Inspector's Report ABP-321056-24

Whether the change of use from ground floor commercial space to 3 bed residential is, or is not development and is, or is not exempted development

Georges Street, Gort, Co. Galway.

ED24/110

CHANGE OF USE OUTLINED BLUE

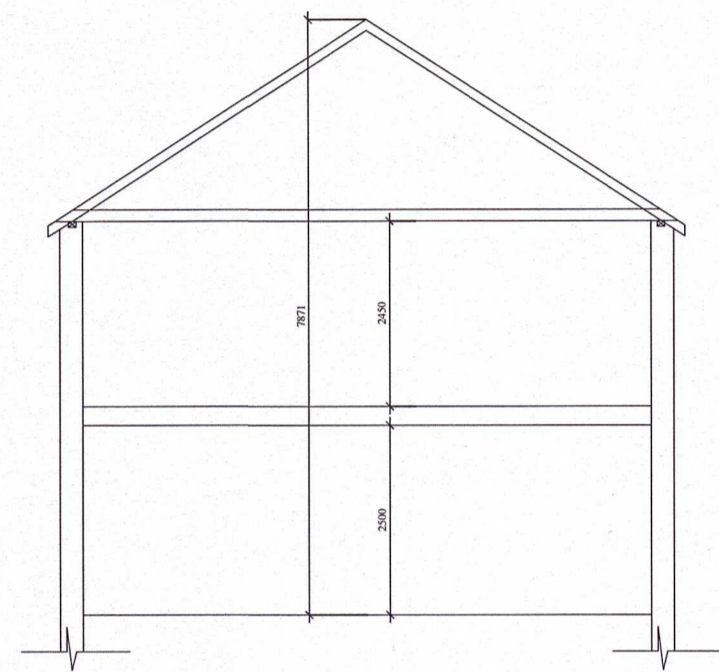
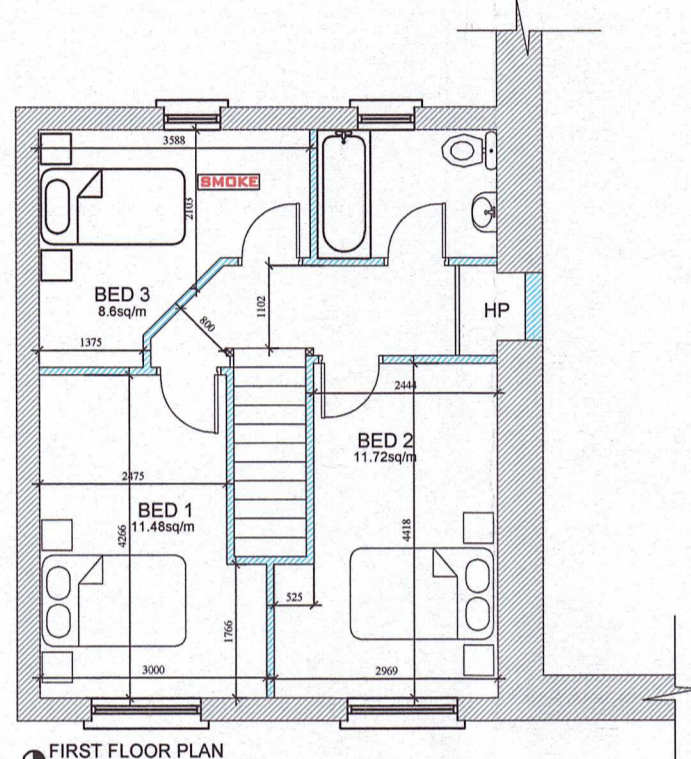
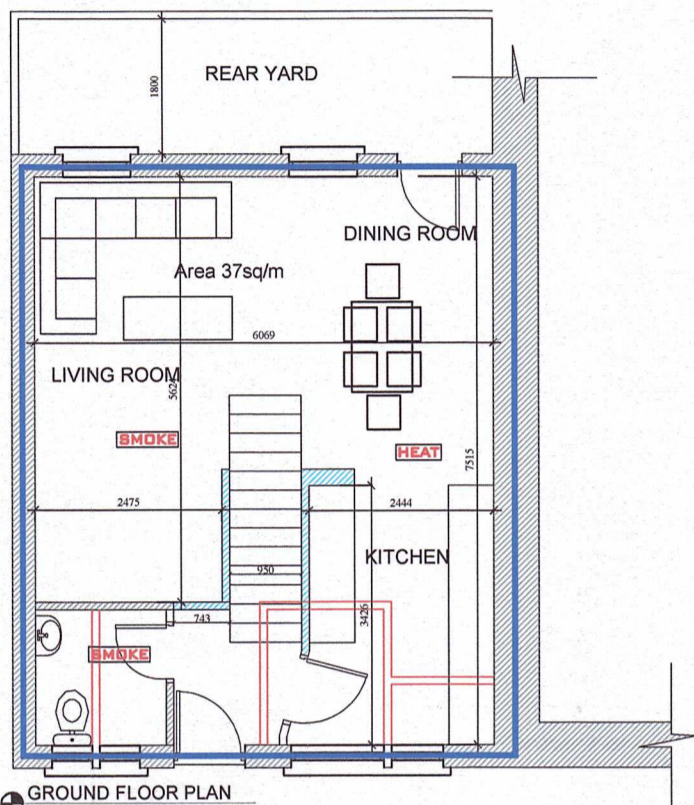
- 9.3.6. However, the proposed residential unit the subject of the proposed change of use is over two floors, and the existing first-floor residential use forms part of a separate property which is an existing residential property facing onto Georges Street.

- 9.3.7. The proposed change of use is reliant on the first-floor residential use, which is a separate unit to the ground floor public house, and this would necessitate the subdivision of an existing residential unit from one existing residential unit to provide for two separate residential units. That being the new residential unit, the subject of this referral, and the existing residential unit which faces onto Georges Street.

- 9.4.6. Notwithstanding compliance with the minimum floor areas for the entire unit and the bedrooms the proposed residential unit does not indicate provision of minimum storage space which is a requirement of Article 10(6)(d)(vi) of the Regulations.
